**KIRKLEES METROPOLITAN COUNCIL
INVESTMENT & REGENERATION SERVICE**

DELEGATED DECISION TO DETERMINE PLANNING APPLICATIONS

Reference No:	2023/62/91299/E
Site Address:	Staincliffe Conservative Club, Chapel Fold, Staincliffe, Batley, WF17 7AY
Description:	Erection of dormer extension, alterations and change of use of former club to restaurant/cafe and 6 flats with car parking and access arrangements
Recommending Officer:	Nina Sayers

DECISION – Full Conditional Permission

Proposed Car Park Elevation

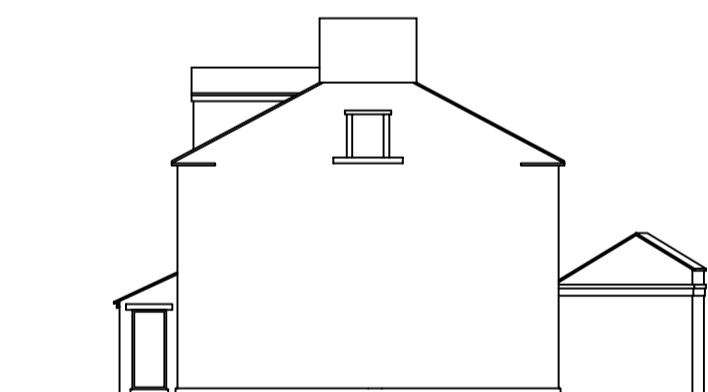
openings on the south-western side elevation, a doorway in the south-eastern elevation, and roof lights and two pitched roofed dormers in the south-eastern elevation.

The proposed changes to openings would be in keeping with the general style and design of the existing openings. The proposed dormer windows would be moderate and set well within the roof space. They would also be located on the south-eastern elevation which fronts the car park thus not impacting on the wider street scene.

Dwg Title			
Single Plan All Information			
Existing and proposed floor plans and Elevations			
Date	SCALE	Drawn	Chk By
141102	As Shown	D Hughes	-
Proj No	Dwg No	Rev	C

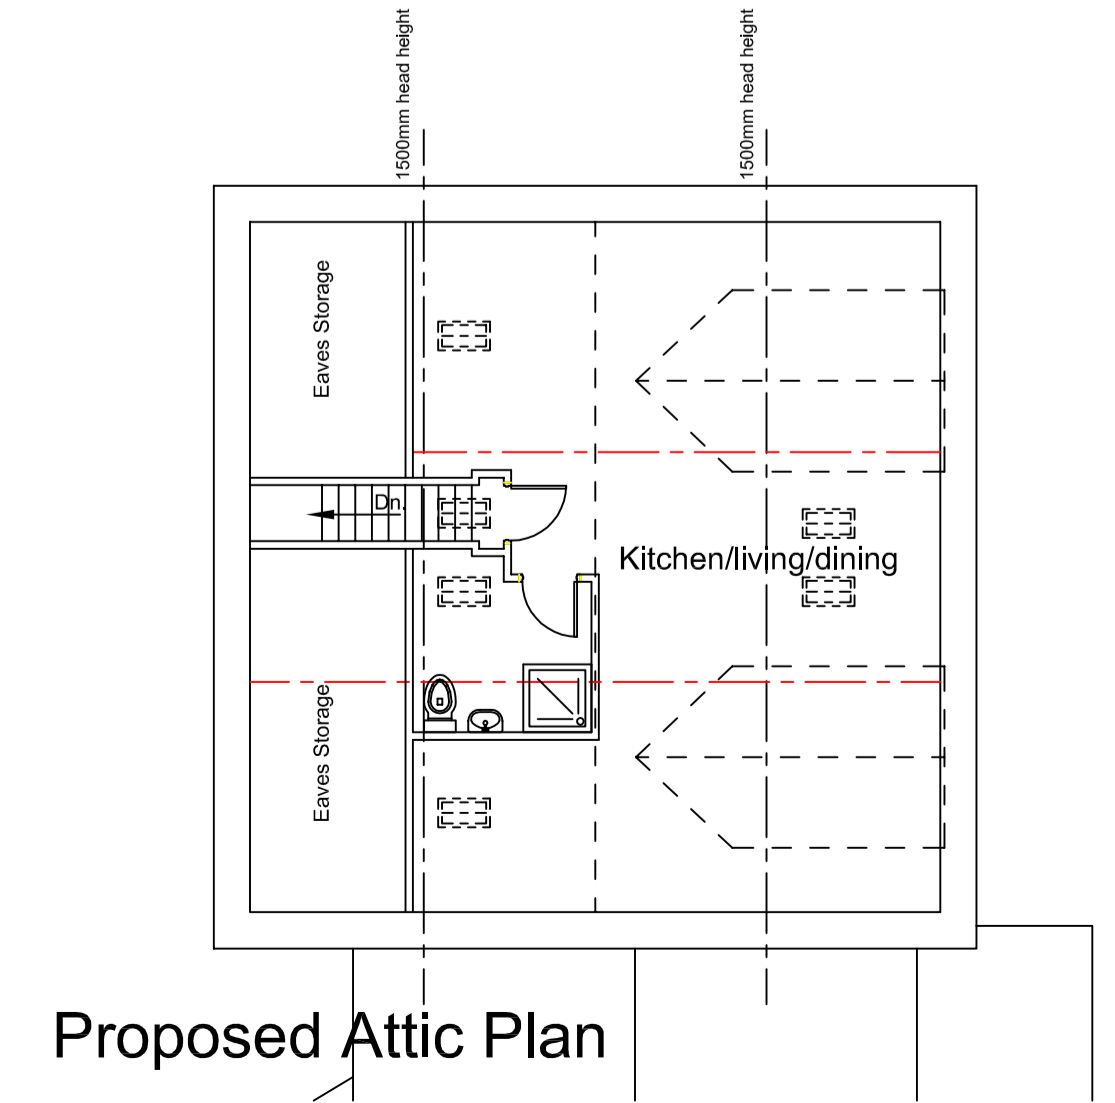
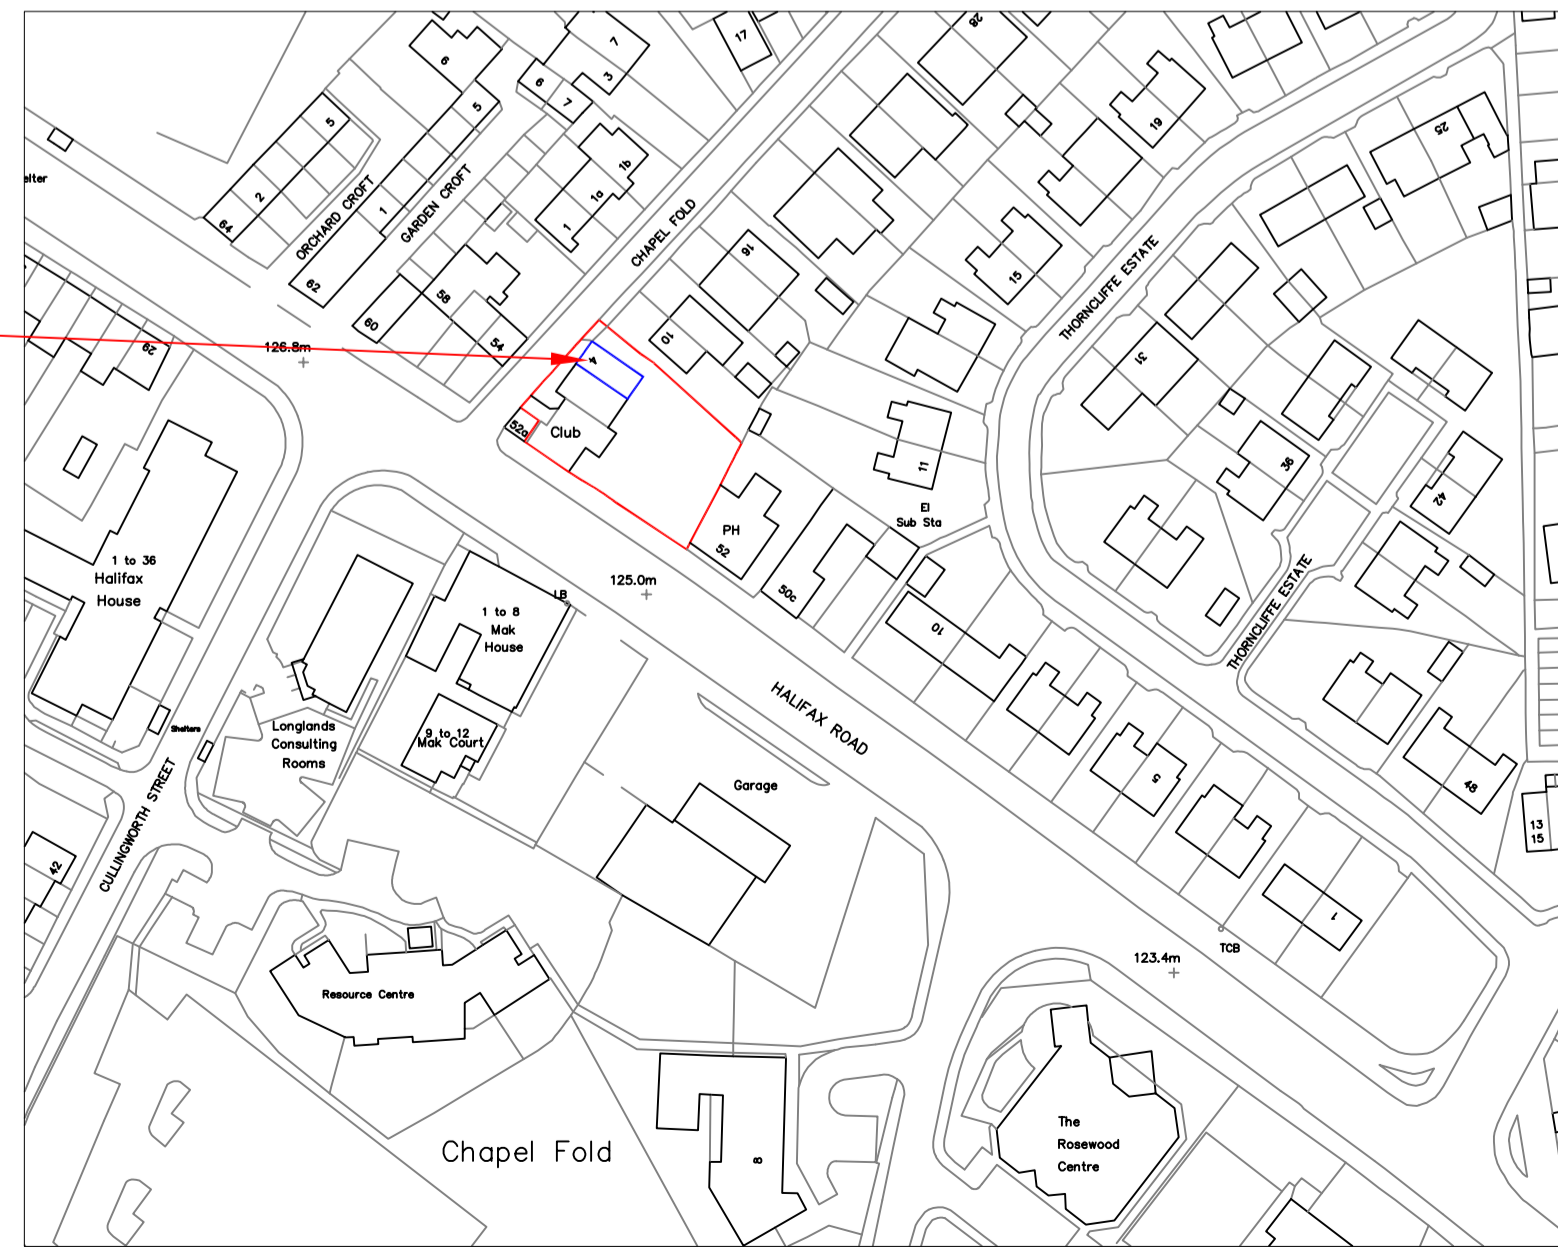
The proposed flats did not initially meet the minimum recommendations as set out within the NDSS for the proposed dwelling types, and therefore officers requested amended plans. The scheme was reduced to 5 residential apartments, all of which comply with the minimum recommendations as set out within the NDSS apart from Flat 1. Flat 1 marginally falls under the recommended limit however the agent has confirmed that this flat is existing

The existing visibility to the southwest of the access off Chapel Fold is restricted due to the existing wall, which currently only allows for a maximum visibility splay provision of 2m x 10m to the southwest. This wall is to be reduced to 700mm high as part of the proposed development which allows for a visibility splay provision of 2m x 26m, where the splay ties into the Halifax Road / Chapel Fold junction

Following concerns raised by KC HDM, the agent provided a revised site plan with a vehicle swept path and HDM were satisfied that this addressed their concerns, subject to conditions requiring that: the wall height be lowered adjacent to the access, details of a right turn lane and ingress/egress signage. In the event that planning permission is approved, conditions to that effect are recommended.

10. There shall be no commencement of the development hereby permitted until the walls adjacent to both accesses have been lowered as demonstrated on the hereby approved Existing and Proposed Floor Plans and Elevations Rev.C. The wall to the Chapel Fold site frontage shall be lowered to a height of 0.7m and shall not exceed this height for the lifetime of the development. The wall to the Halifax Road frontage shall be lowered to a height of 1.0m and

11. Prior to development commencing, a detailed scheme for the provision of a right turn pocket within the existing central white line hatching from Halifax Road into the site shall be submitted to and approved in writing by the LPA. The scheme shall include construction specifications, white lining, signing, surface finishes together with an independent Safety Audits covering all aspects of the work. Unless otherwise agreed in writing by the LPA, all of the agreed works shall be implemented before any part of the development is first brought into use and thereafter retained. This is a pre-commencement condition to ensure that any risk to highway safety is identified at the outset and that appropriate mitigation, should any be necessary, is implemented at the appropriate stage of the development.
